## **A46 Newark Bypass**

**Scheme Number: TR010065**

### **7.62 Comments on submissions received at the previous deadline**

**Comments on submissions received at the previous deadline**

**Viewpoint 24: View north from Sandhills Park representative of views for residents.**

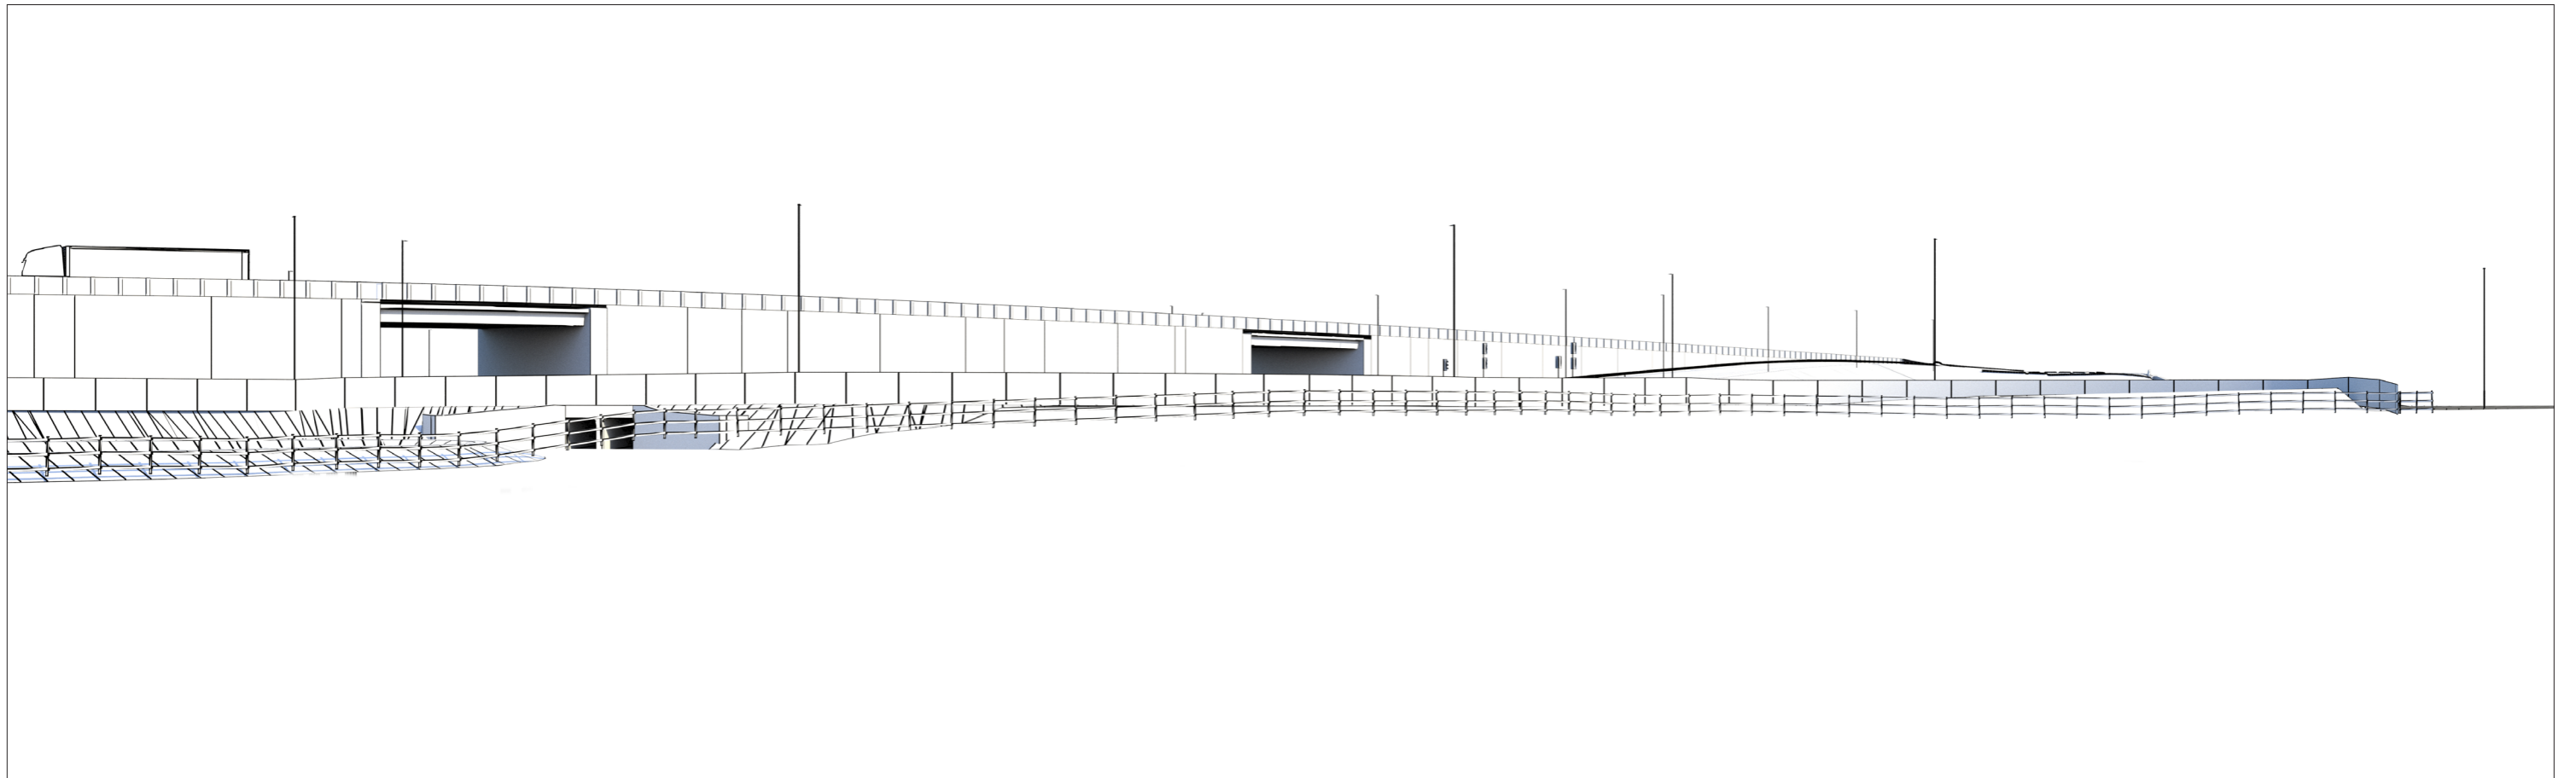
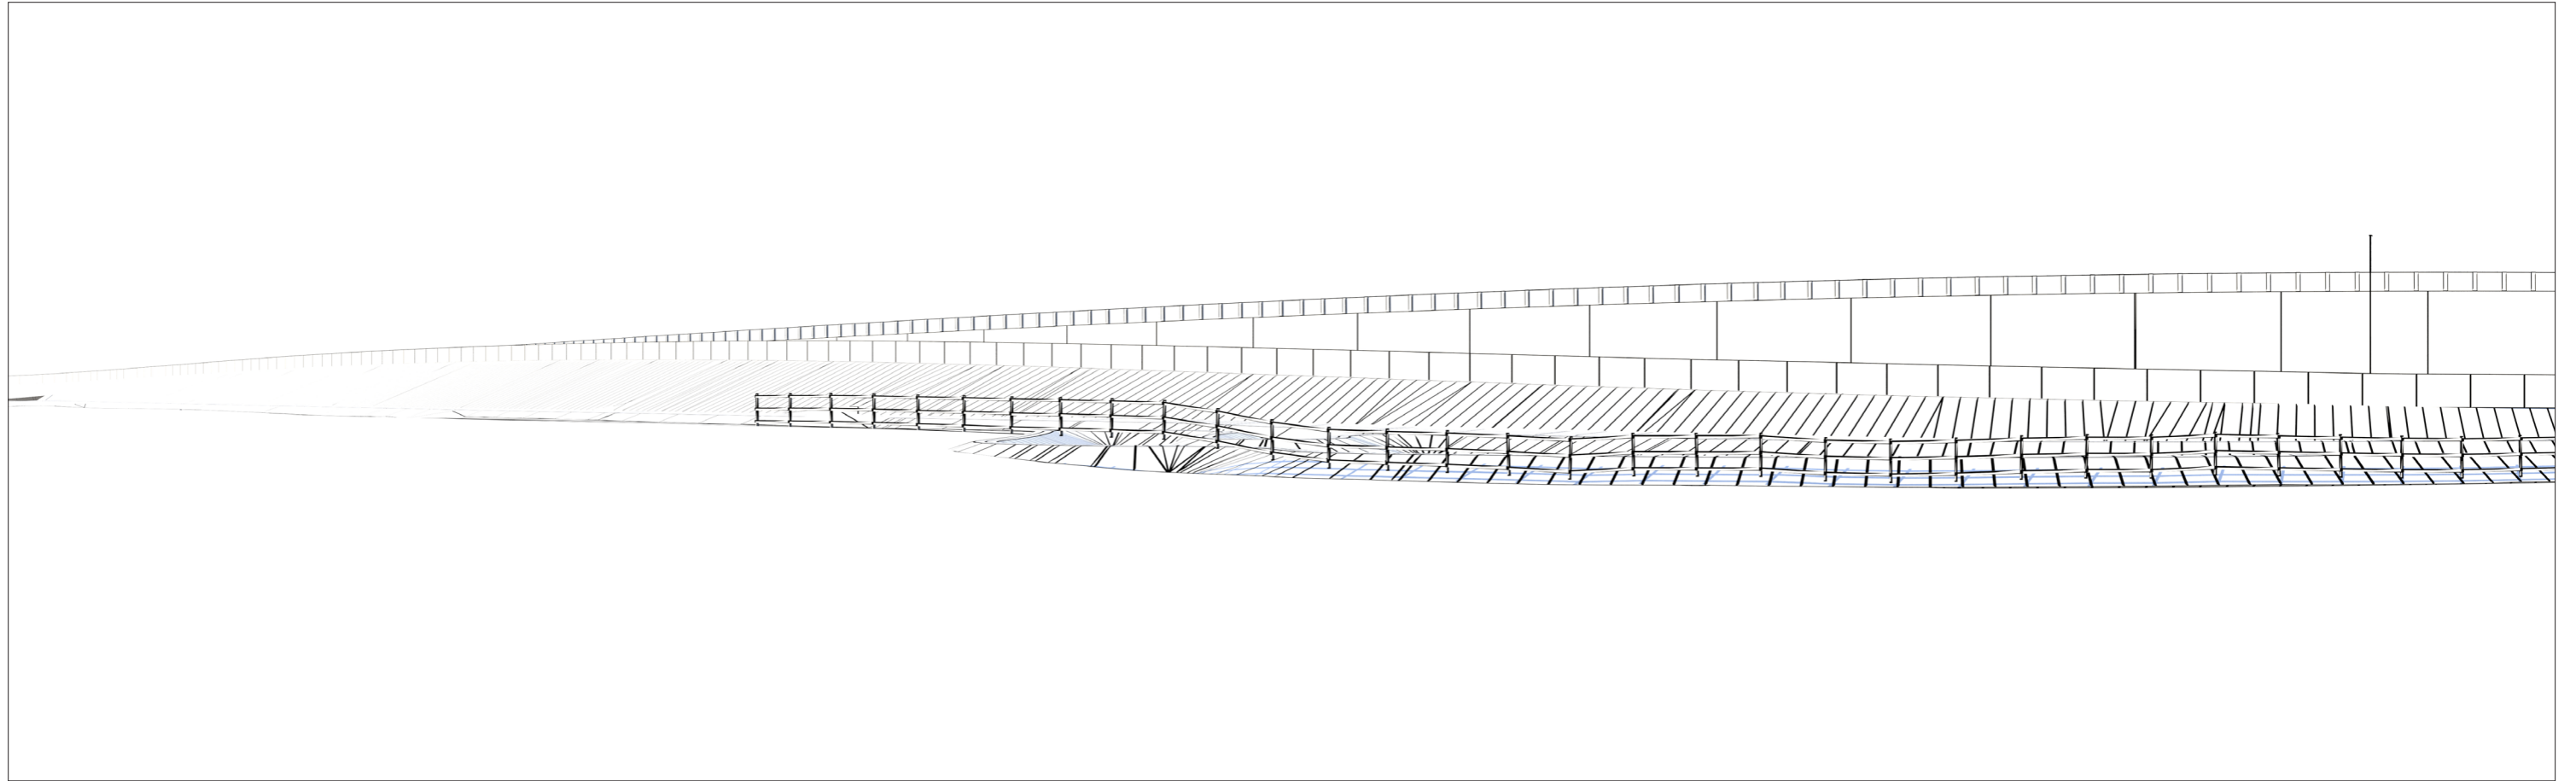
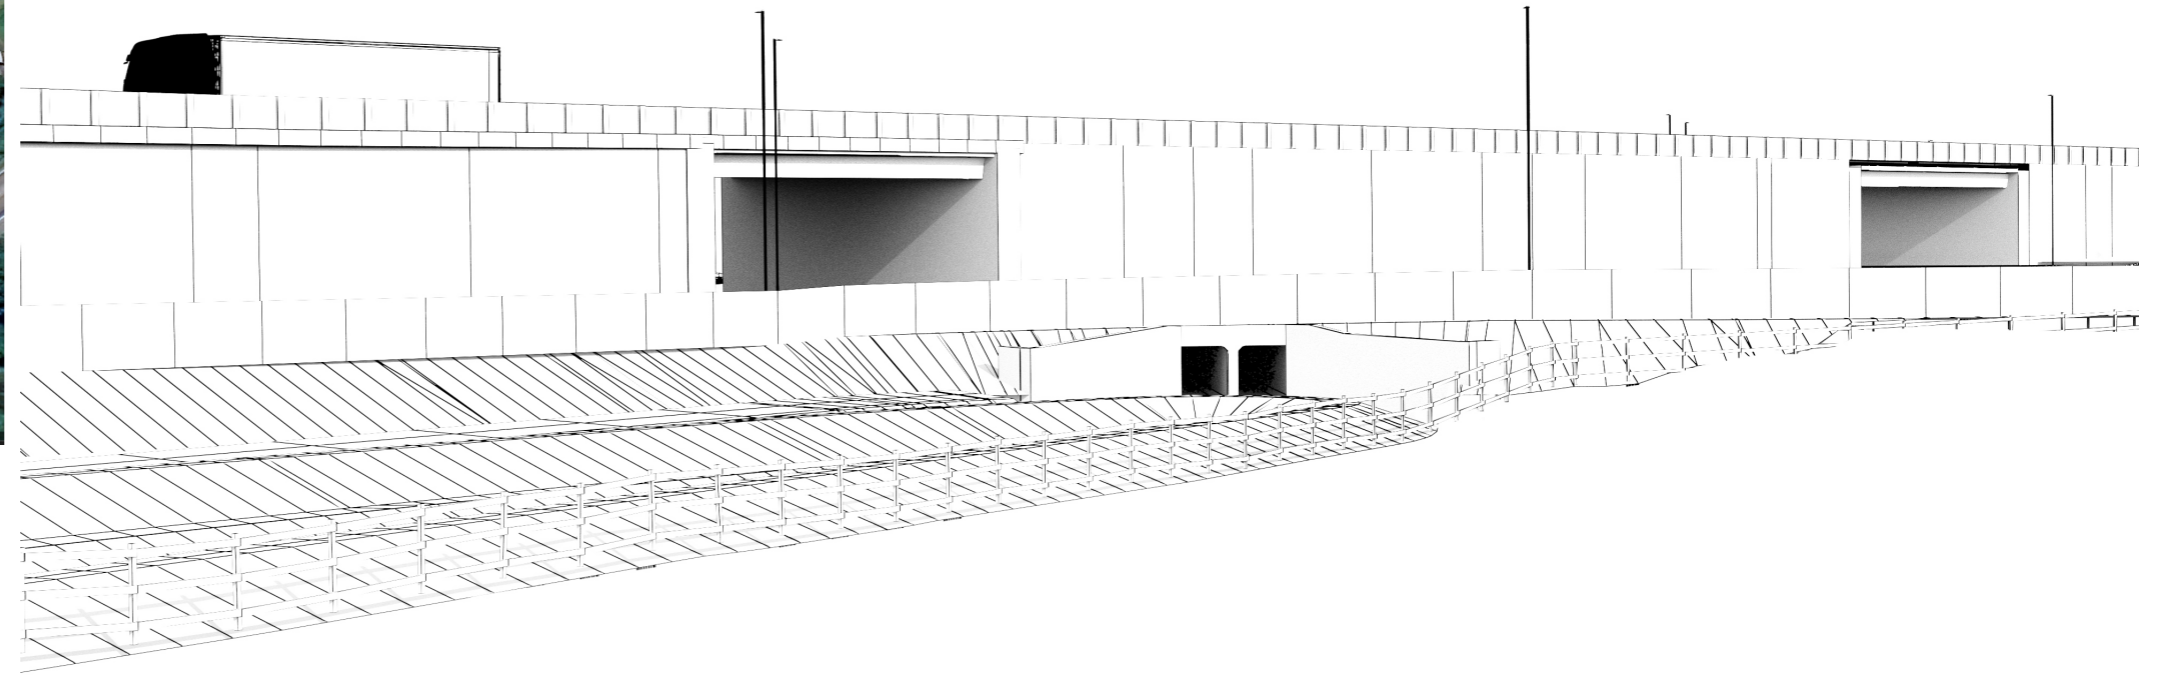
2.27. <b>Item 4b) Viewpoint 24 Sandhills Park</b> (REP2-020) – The Council does not consider that the visual representation is sufficient to represent how those residents of Sandhills Park would experience the levels change from the Cattle Market flyover. Given the intervening buildings on the plan it was suggested that a view from the A617 could show the full extent of the impact for those residents, without having to enter residents gardens or properties if this was not possible. Comments on this have been submitted by the Council as REP3-046.	The Applicant has provided a response in "Additional Visual Effects Information following Issue Specific Hearing 4 - Rev 1" [REP4-039] submitted at Deadline 4 of the Examination.

**Viewpoint 25: View south from Great North Road (A616) representative of views for road users**

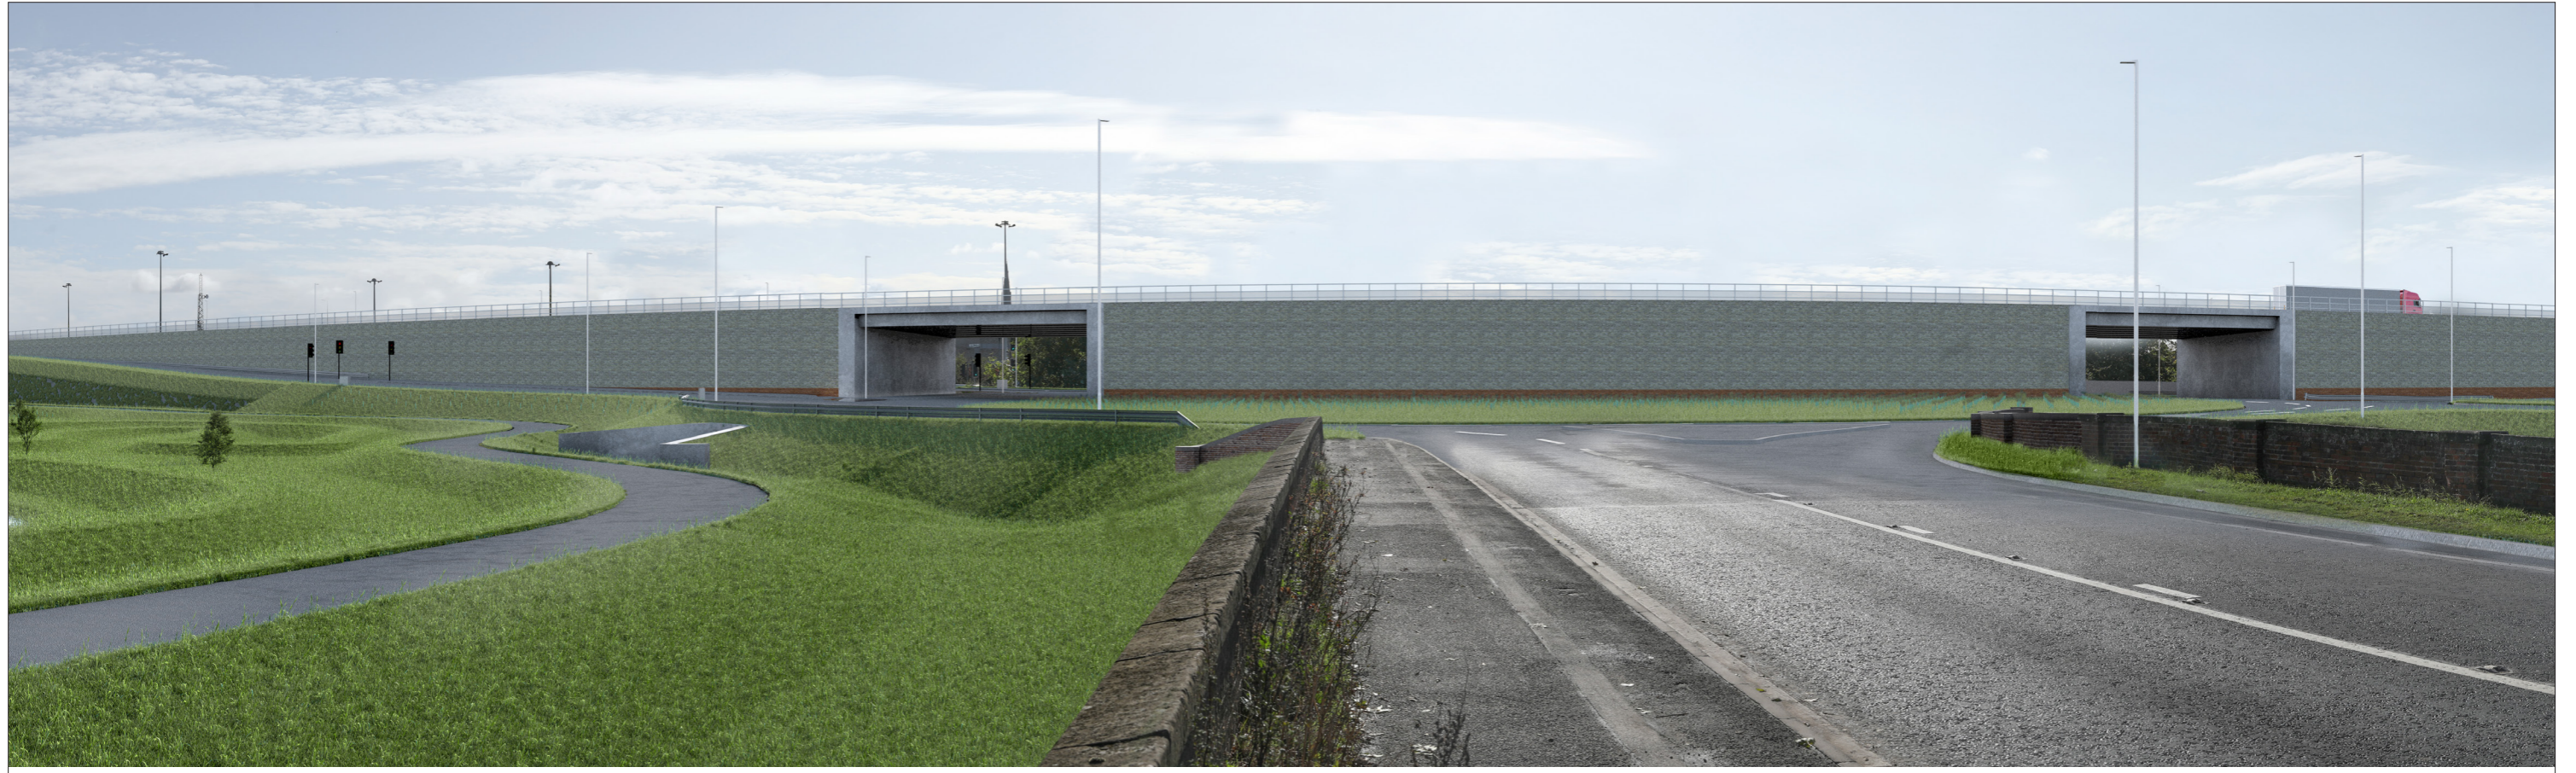
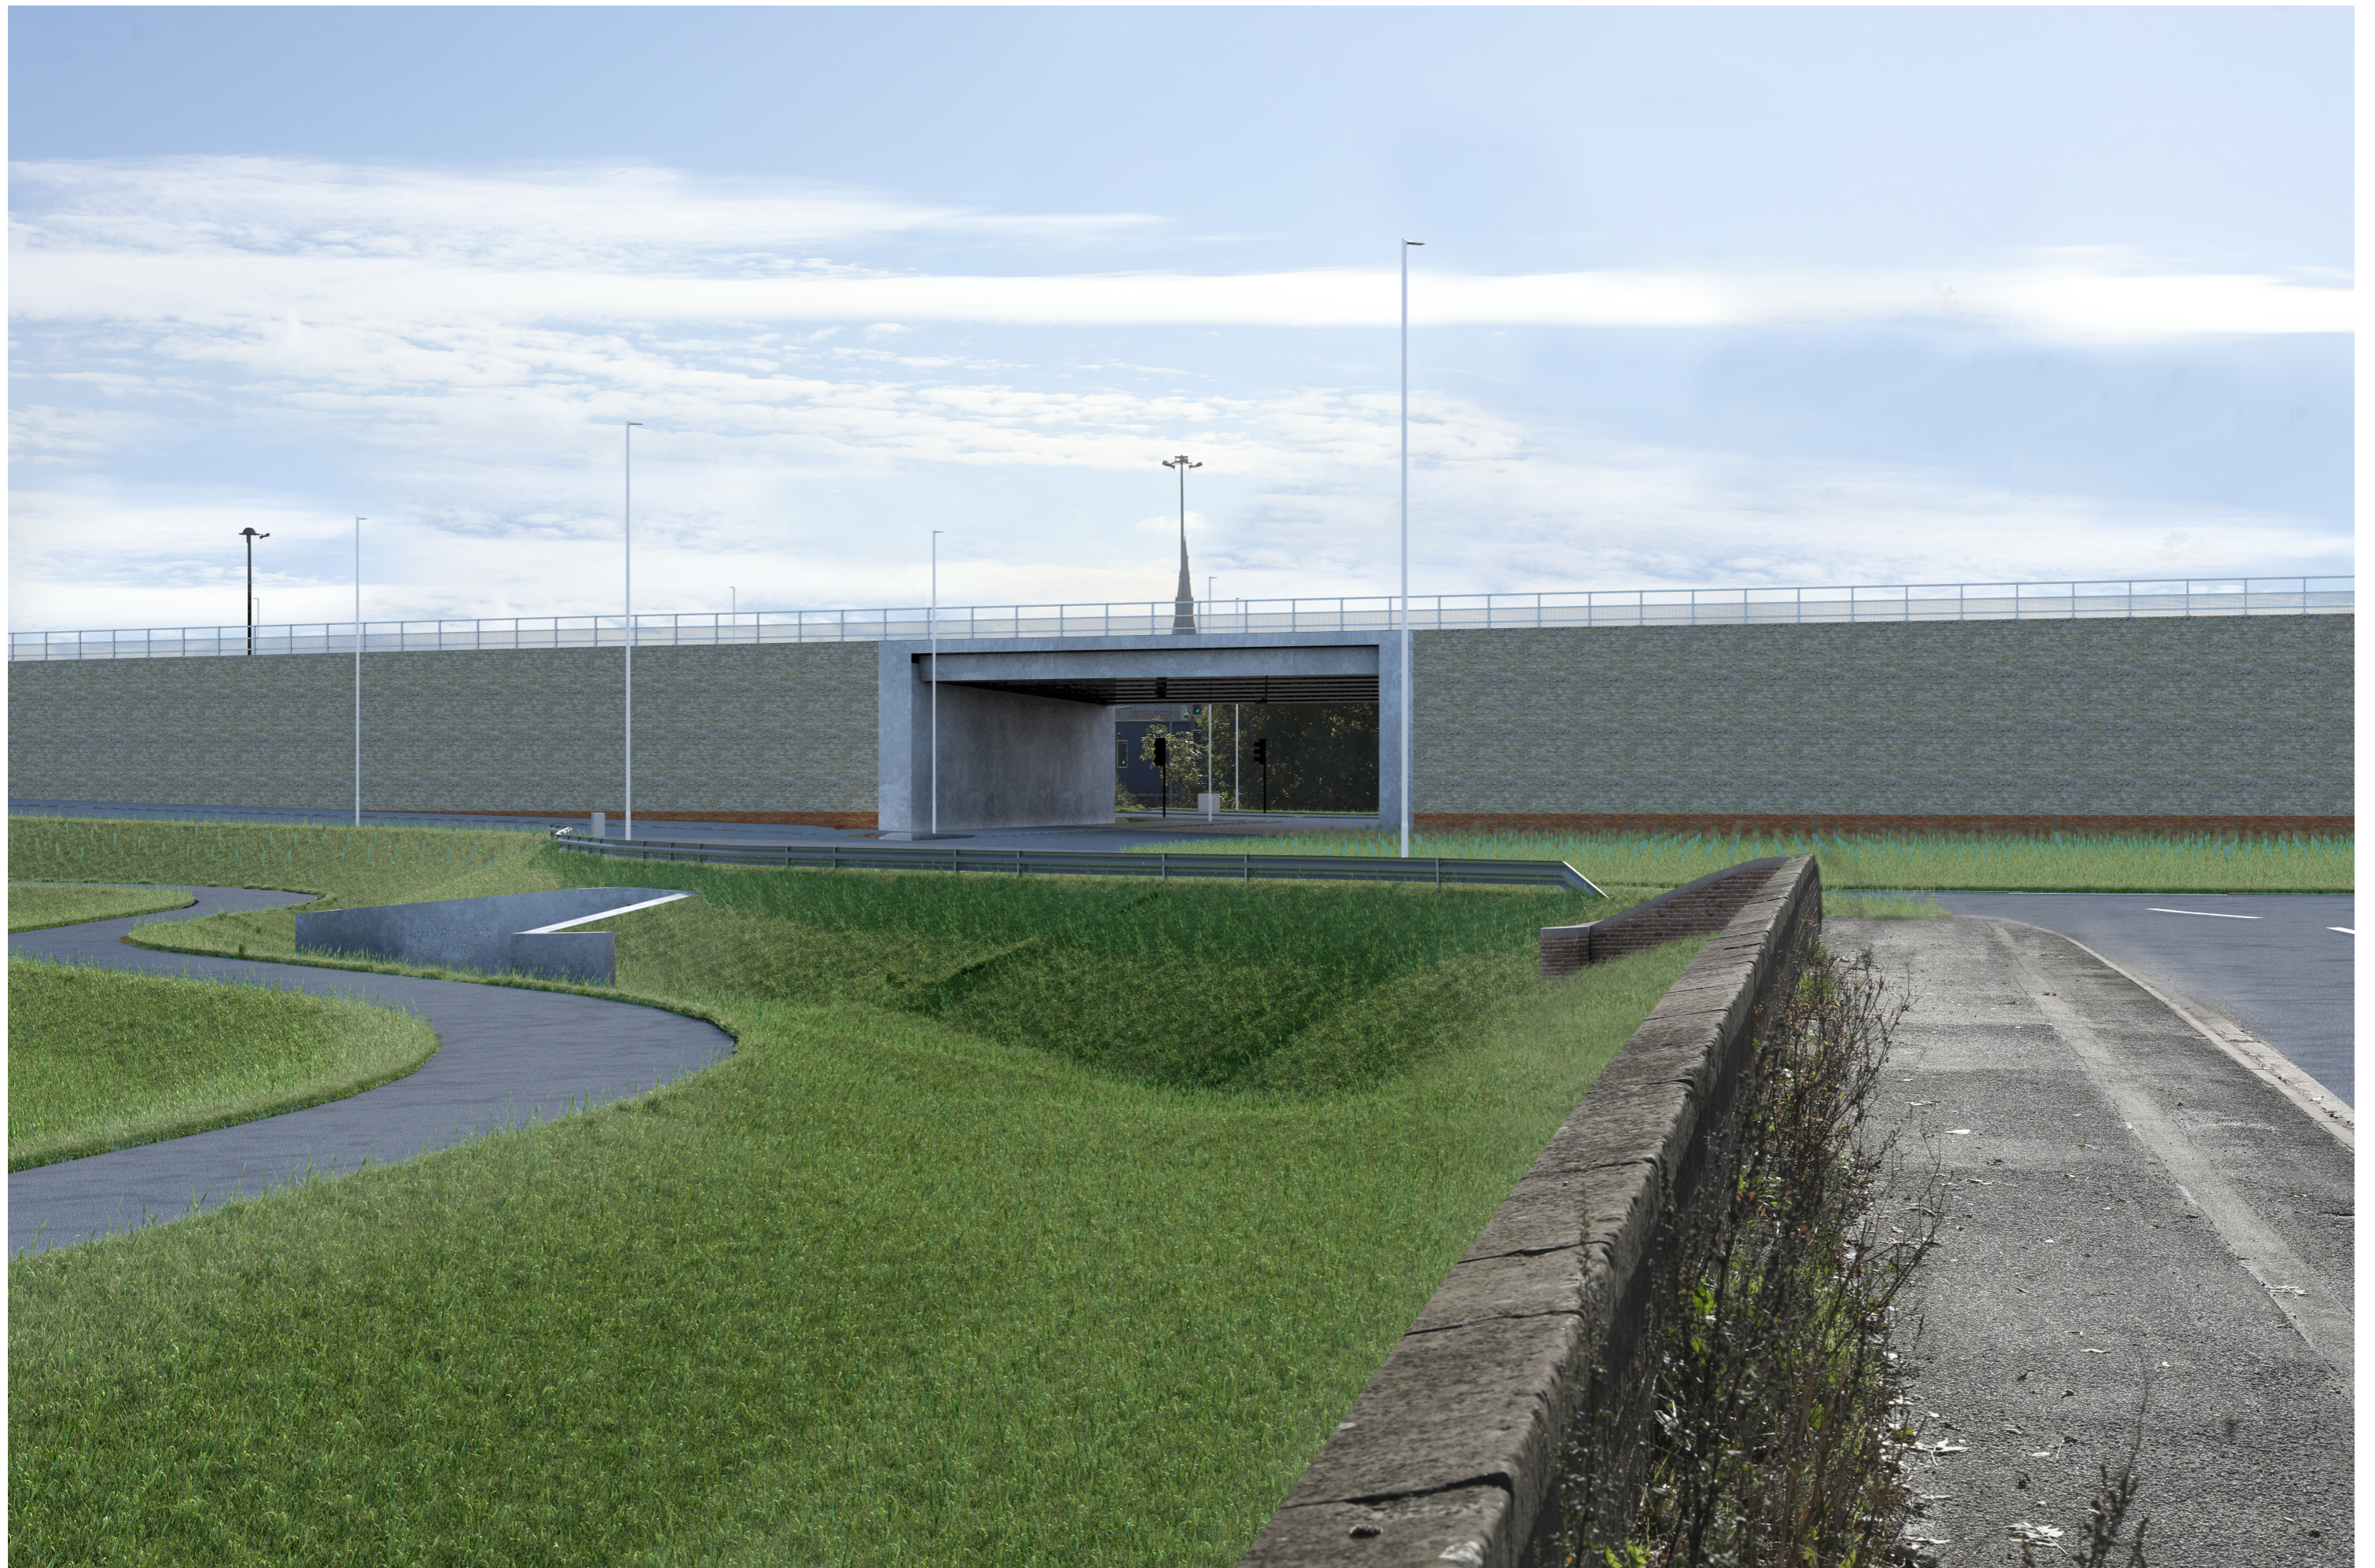
2.26.	<b>Item 4a)</b> Cattle Market junction – The Council reiterates that the landscaping around this junction is insufficient to respond to the character or to provide sufficient mitigation to the impact of the flyover. At present the landscape is dominating with the infrastructure low lying in most places (especially on this roundabout section). To create	The Applicant confirms that at the location of representative viewpoint 25, as assessed within Chapter 7 (Landscape and Visual Effects) of the Environmental Statement [APP-051], roadside vegetation does frame views of the highway looking south to Cattle Market Junction and will continue to do so during the operation of the Scheme, as it will be sufficiently retained during construction
